12-16 BENT STREET - LINDFIELD

LANDSCAPE RESPONSE TO SDRP REVIEW 2 (2 APRIL 25)

S24-01924 • 25/09/2025

COMMUNAL OPEN SPACE

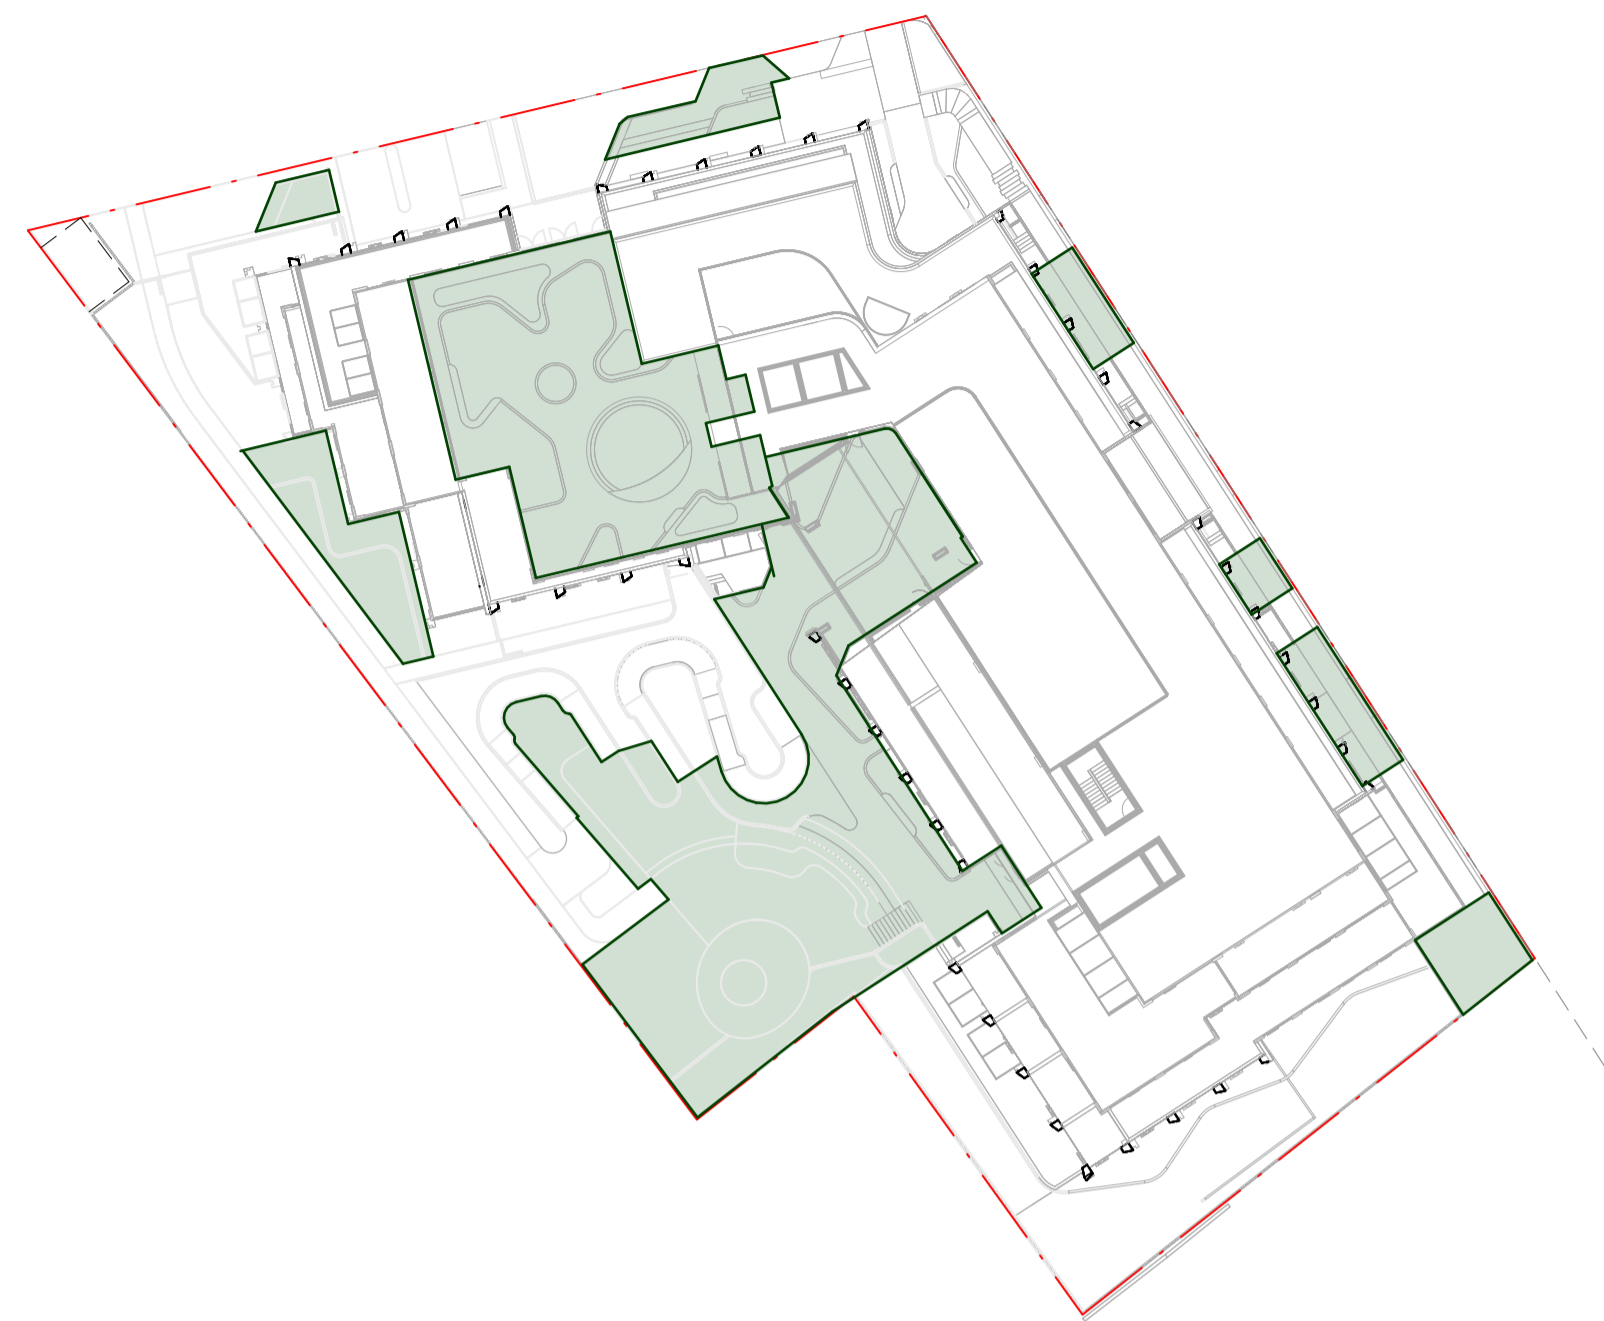
- Recalculate the area of the COS considering the useable and functional parts, as recommended by the ADG. Walkways and buffer zones with landscaping should not be included in the calculation of the principal COS area.

- The principal Communal Open Space area has been recalculated to exclude walkways and buffer zones with landscaping. To satisfy the 25% ADG requirement, additional communal open spaces have been added at the southwest walkway area and along the internal walkway at the Drovers Way interface.

COS Solar Analysis 21 June 9AM to 3PM

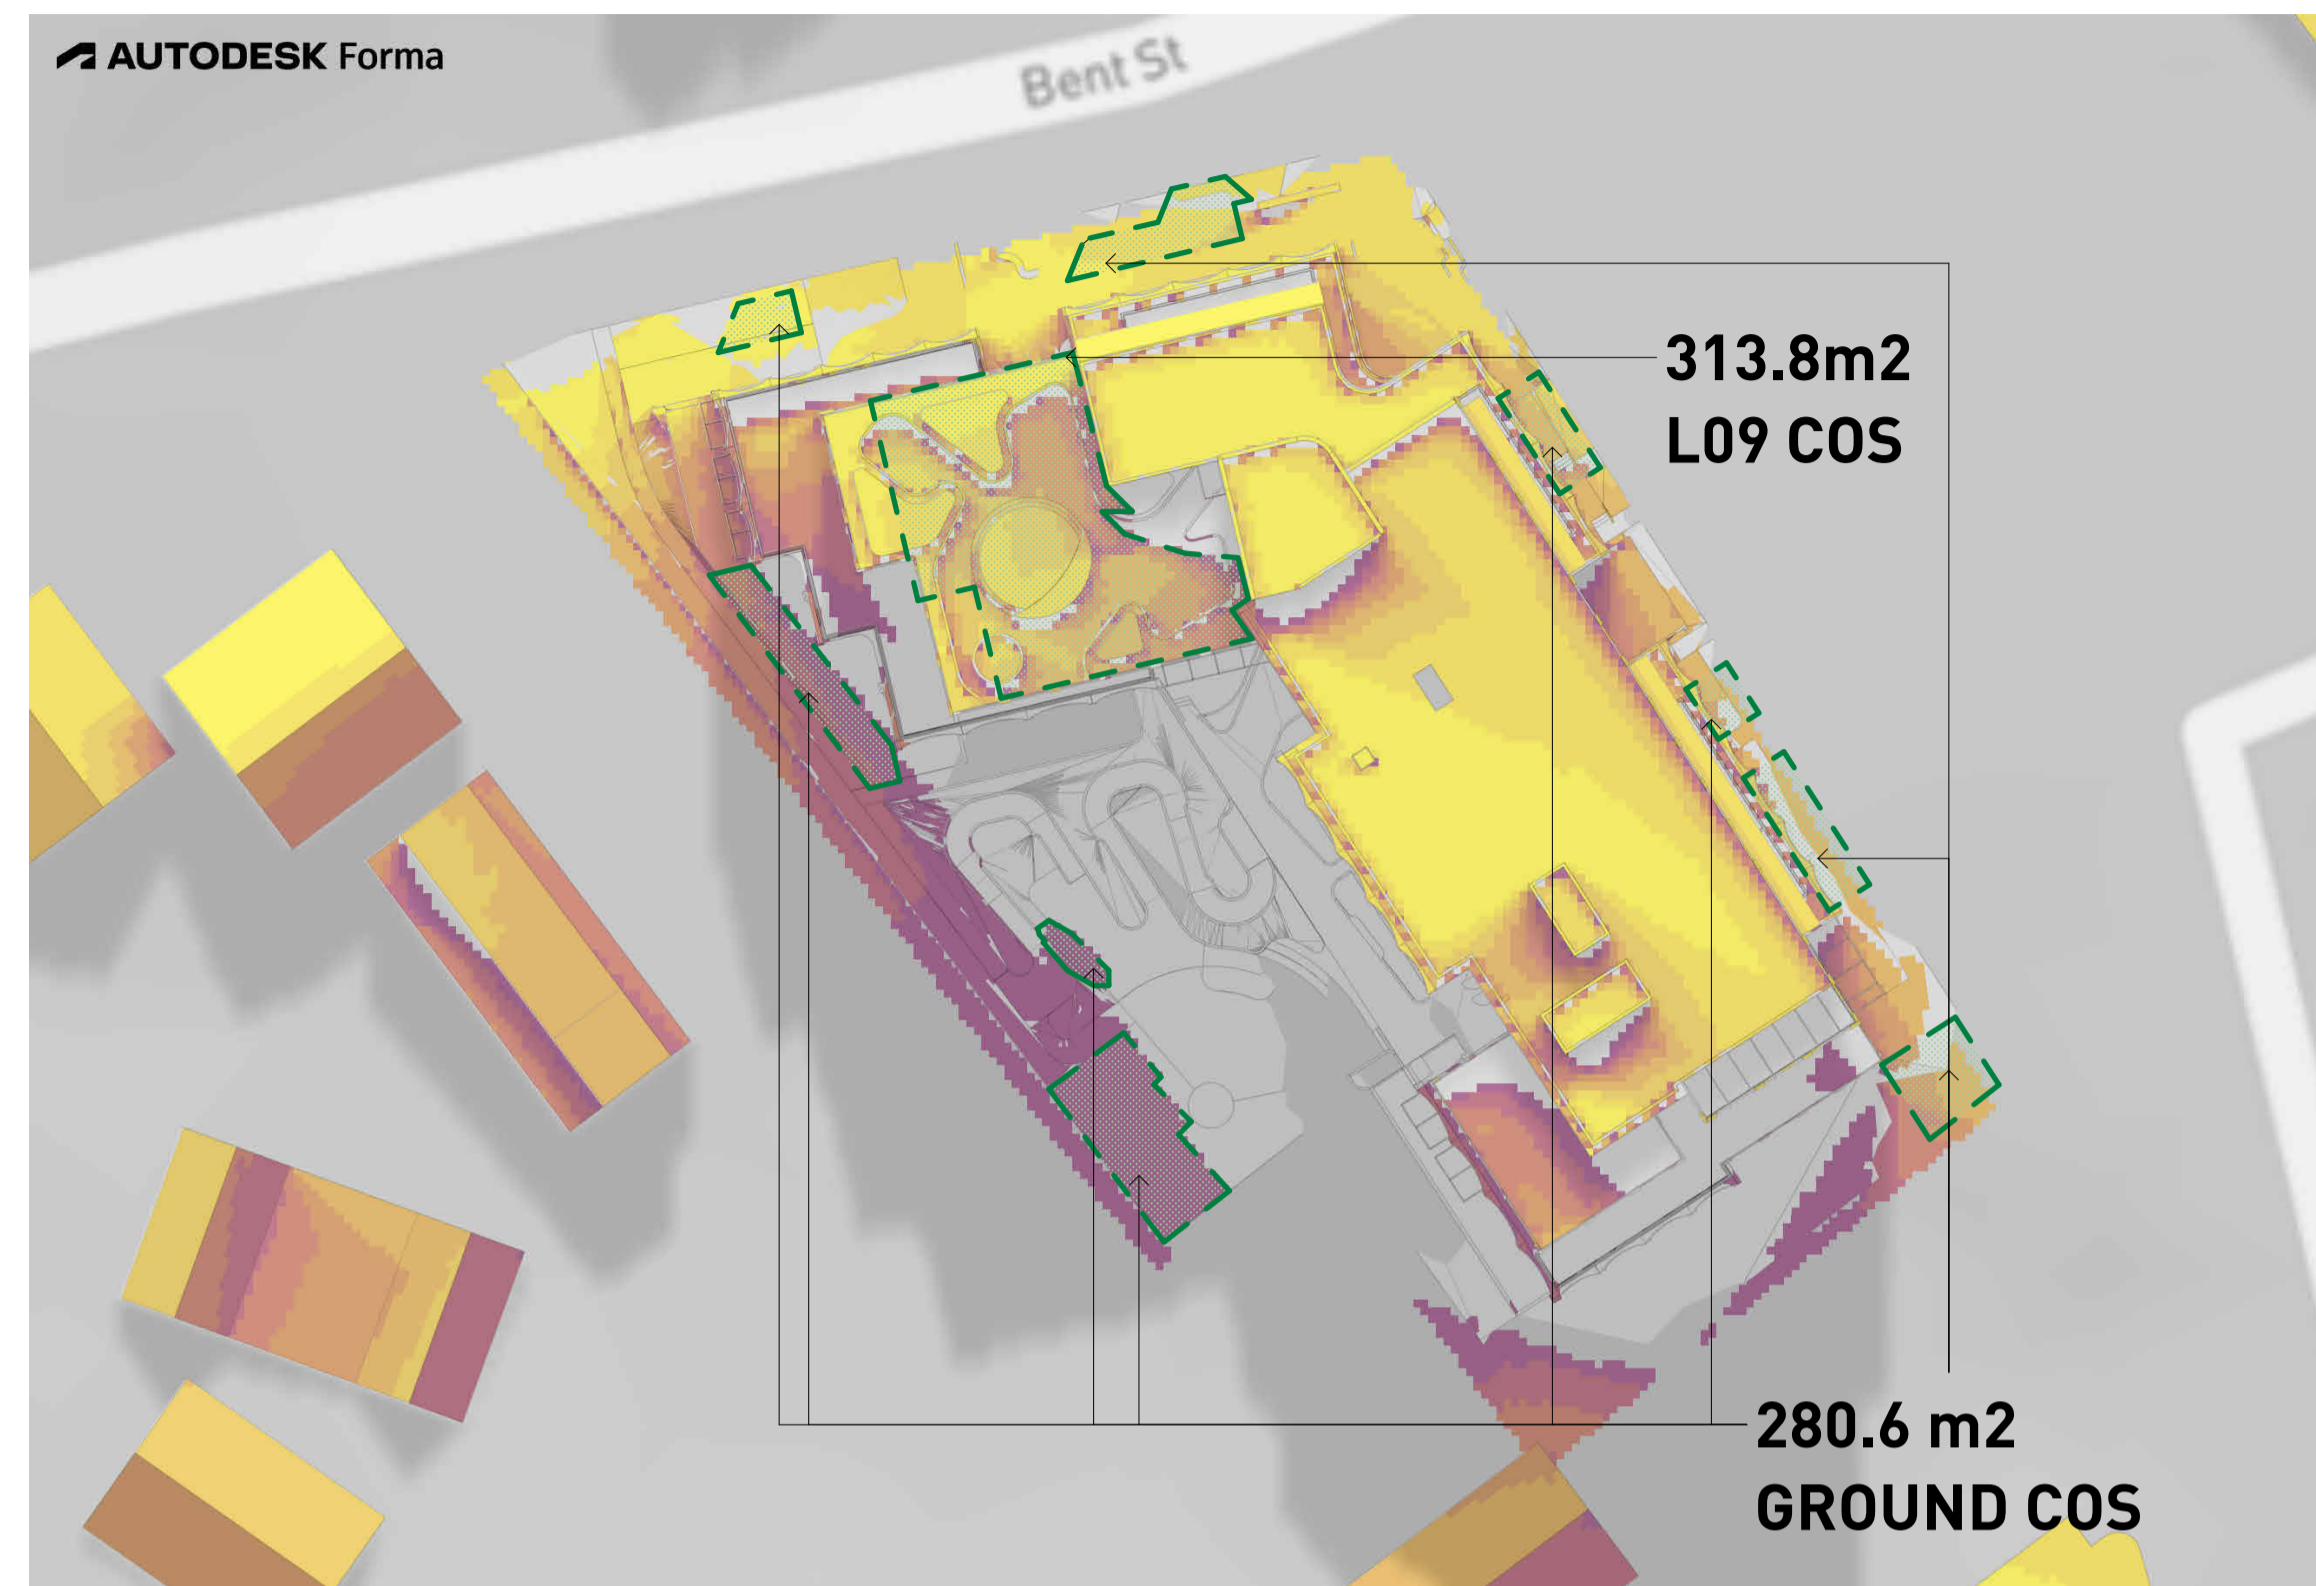
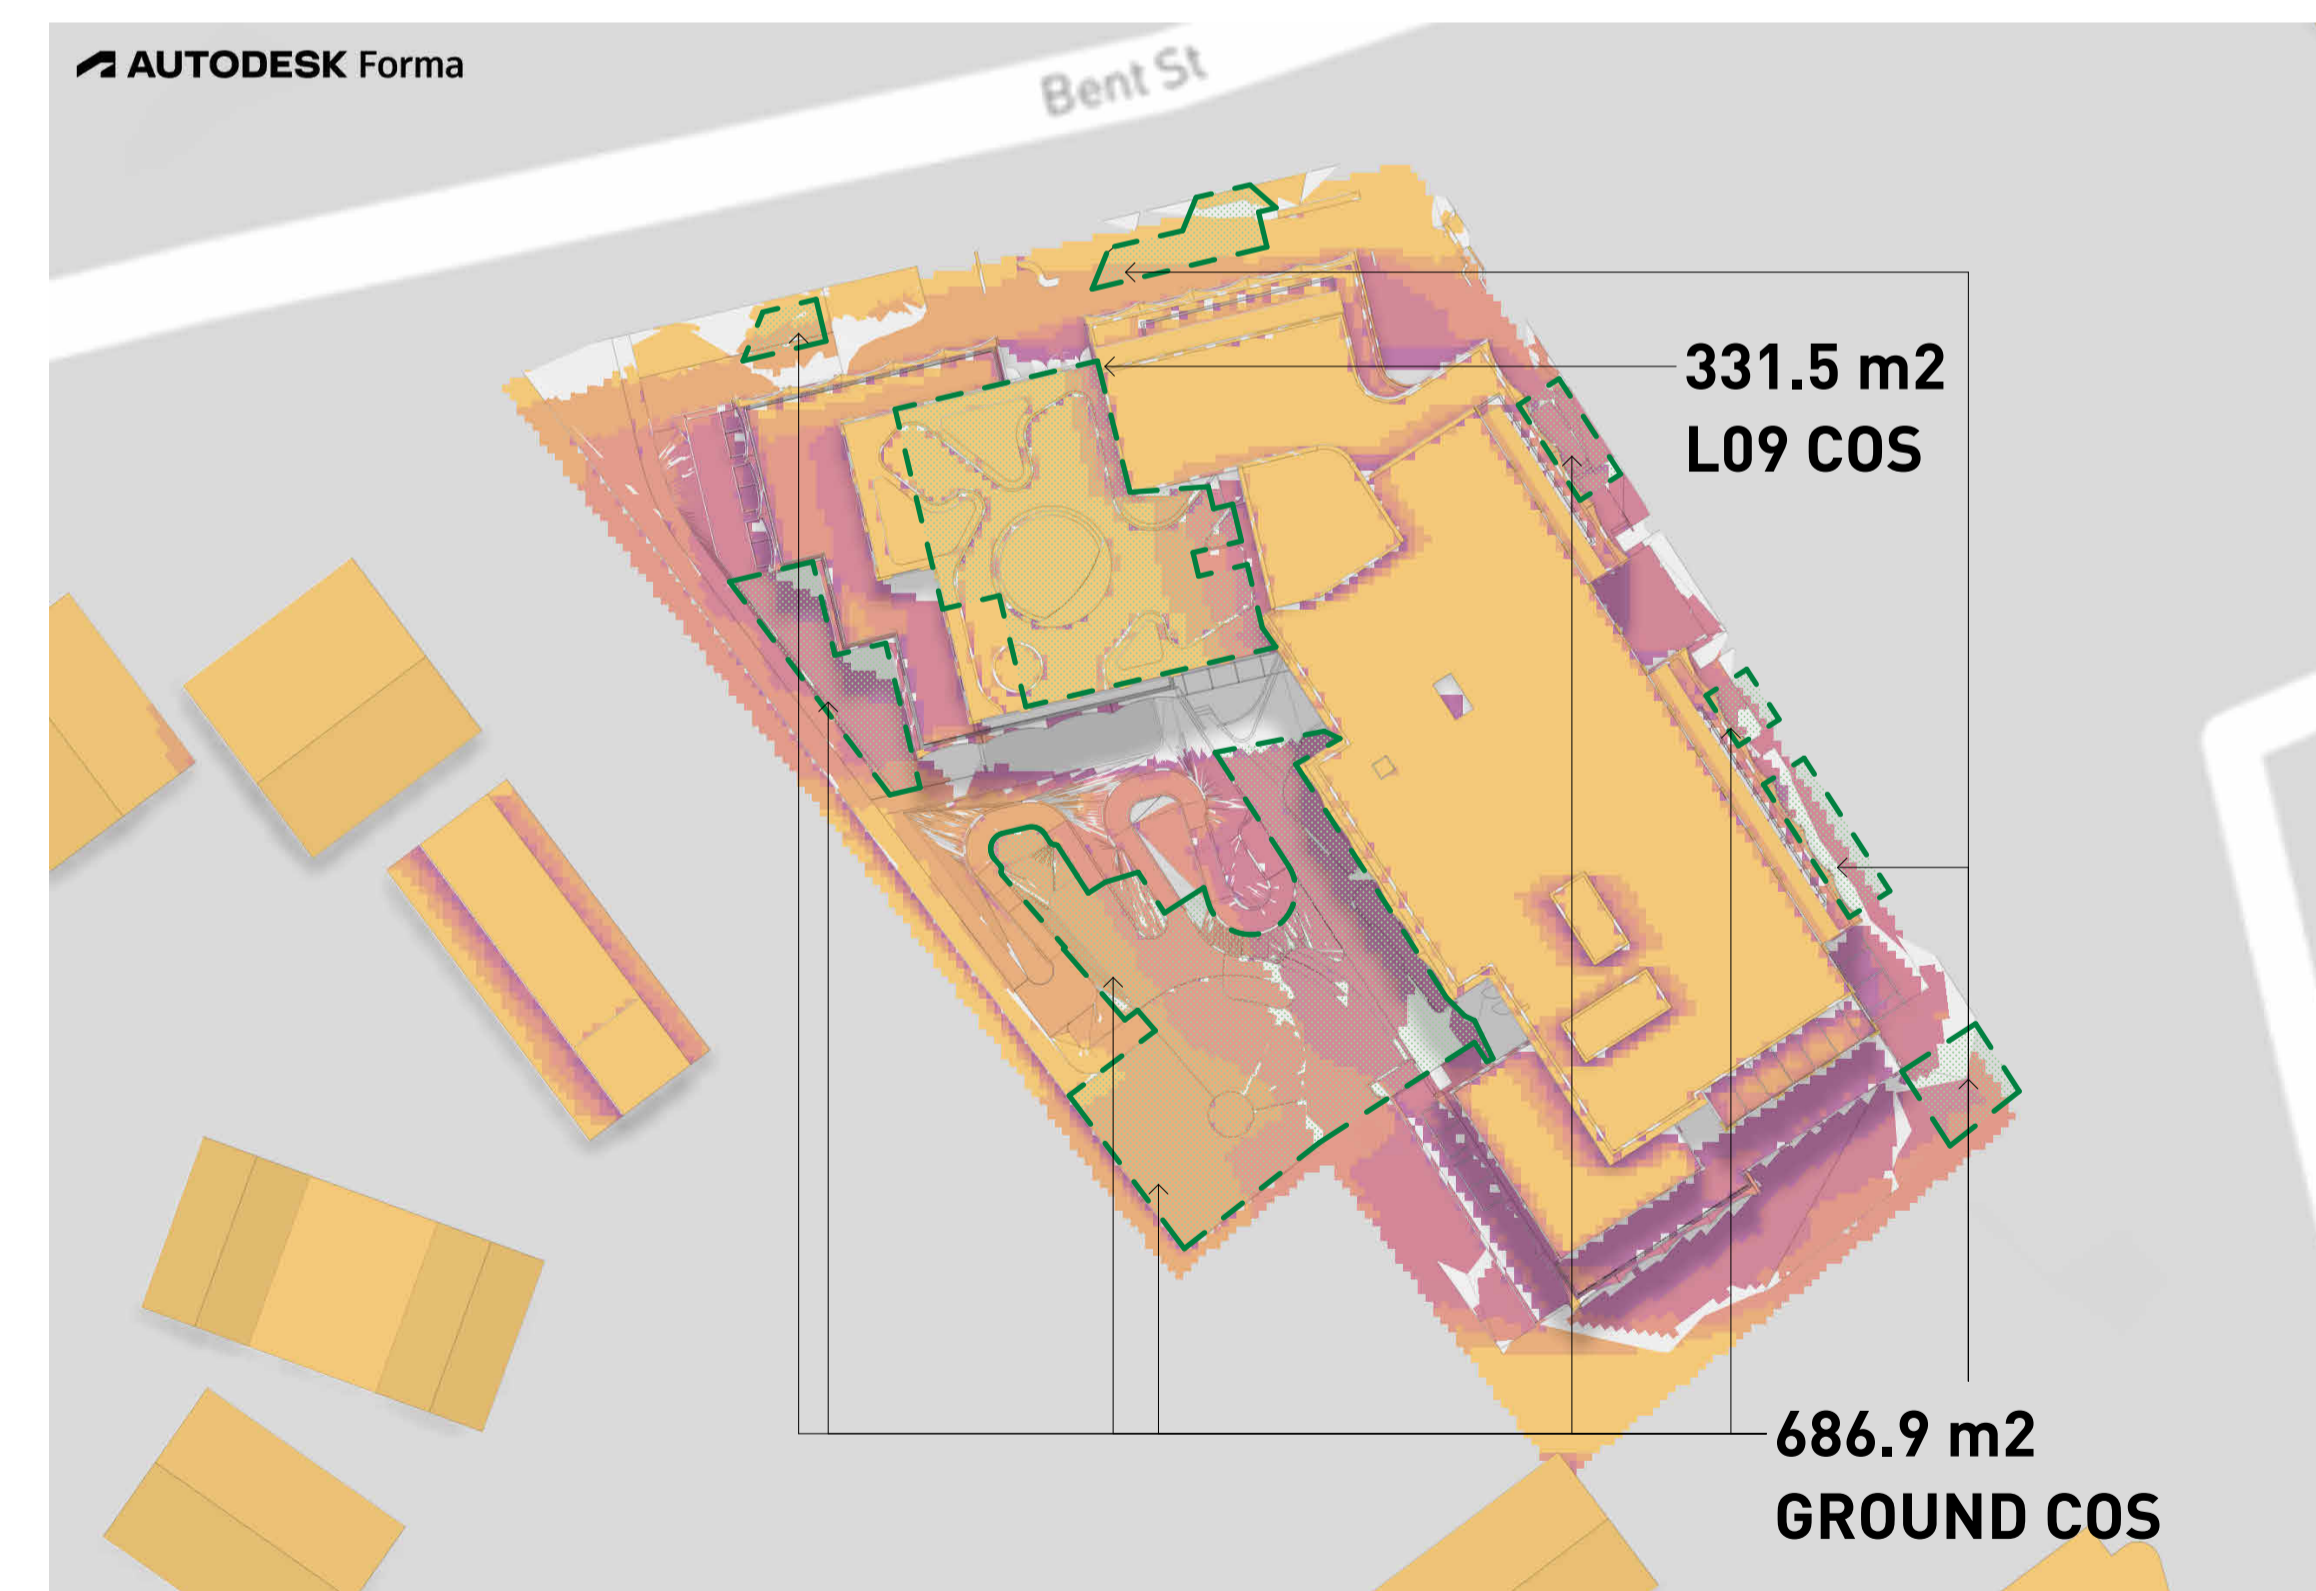
- Demonstrate what percentage of the proposed rooftop COS area receives two hours of solar access between 9am – 3pm mid-winter, having regard to the ADG design criteria.

- The Level 9 COS will receive in excess of 2 hours sunlight during mid-winter, refer to updated solar access diagrams on the right as extracted from the architectural drawings.
